Recommendation Report for Planning Permission for Works or Extension to a Dwelling

REF NO: FP/157/20/HH

LOCATION: 24 Goodwood Avenue
Felpham
PO22 8EH

PROPOSAL: Proposed Roof Extensions & Alterations

CLIENT	Mr & Mrs J Fowles	DRAWING	003 Proposed Elevations
SITE	24 Goodwood Avenue, Felpham	DATE	20 08 20
PROJECT	Proposed Extensions & Alterations	SCALE	1: 100 @ A3
		AUTHOR	AH
		STATUS	PL

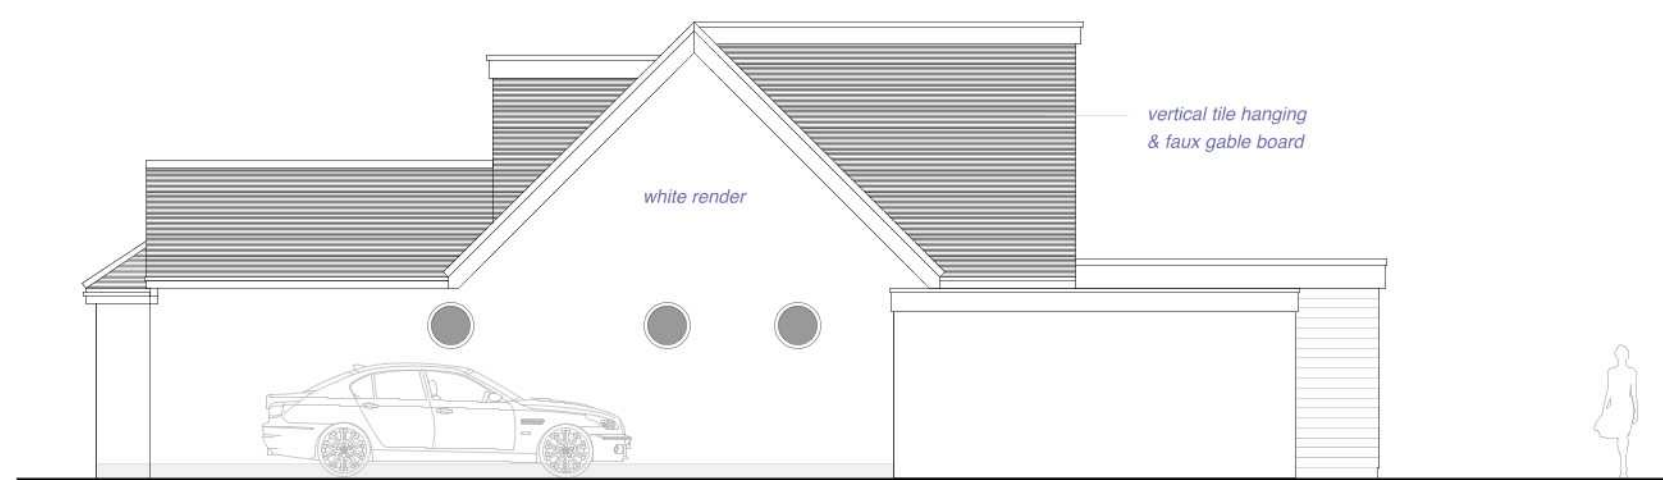
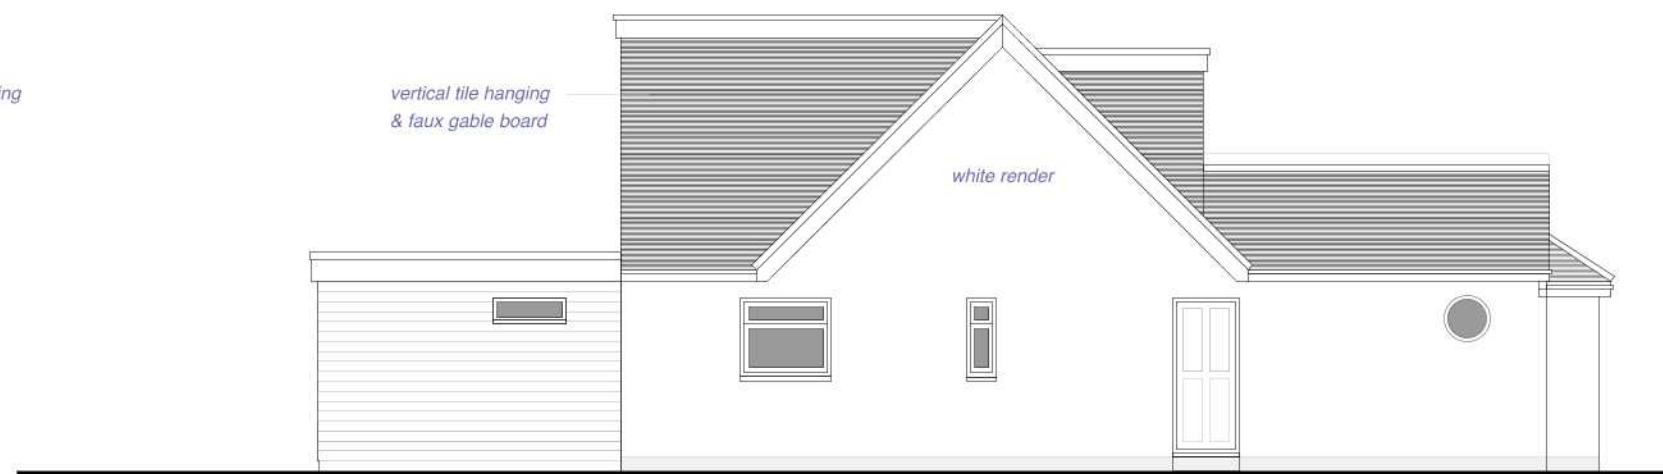
There are two pitched elements to the front of the dwelling with a hipped roof behind. The hipped element will alter to form a gable which will result in the height increasing by approximately 0.6m to form a ridge height of 6m.

Due to the scale of the changes with the height increasing, the development is not considered a subservient addition. The works are however well integrated and will use white render and tile hanging to match the materials of the existing dwelling.

There will also be a dormer facing the street scene. This will have a height of 2.25m and a depth of 2.2m, although is not considered to appear unduly dominant upon the principle elevation.

The neighbouring properties at No. 26 and No 22 have two ground floor windows to the west and east elevation and whilst the proposal will add bulk, this is not considered to result in an adverse overbearing or overshadowing impact upon amenity. This is due to the bulk of the increase situated behind existing pitched elements, towards the rear of the dwelling, slightly beyond neighbouring windows.

A rear dormer will also be constructed. This will have a depth of 5m with a height of 5.4m meeting with the ridge height of the dwelling. This will also extend beyond the roof slope onto an existing rear flat roof by around 1.75m. Whilst this is large, there is 2.3m retained to the eastern boundary and 1m with the west with a garage also to the neighbouring elevation. The development does not extend beyond the rear of neighbouring properties and is not considered to result in adverse harm upon neighbouring amenity.

The dormer to the rear will have a two windows serving a bathroom and a bedroom. These will provide additional views of the rear gardens however is not considered to result in adverse overlooking with no views into direct properties. The dormer to the front will provide additional views over the street scene. It is appropriate to require the bathroom window to be obscure glazed in the interests of amenity.

- 3 The bathroom window in the rear dormer of the building shall at all times be and remain glazed entirely with obscure glass.
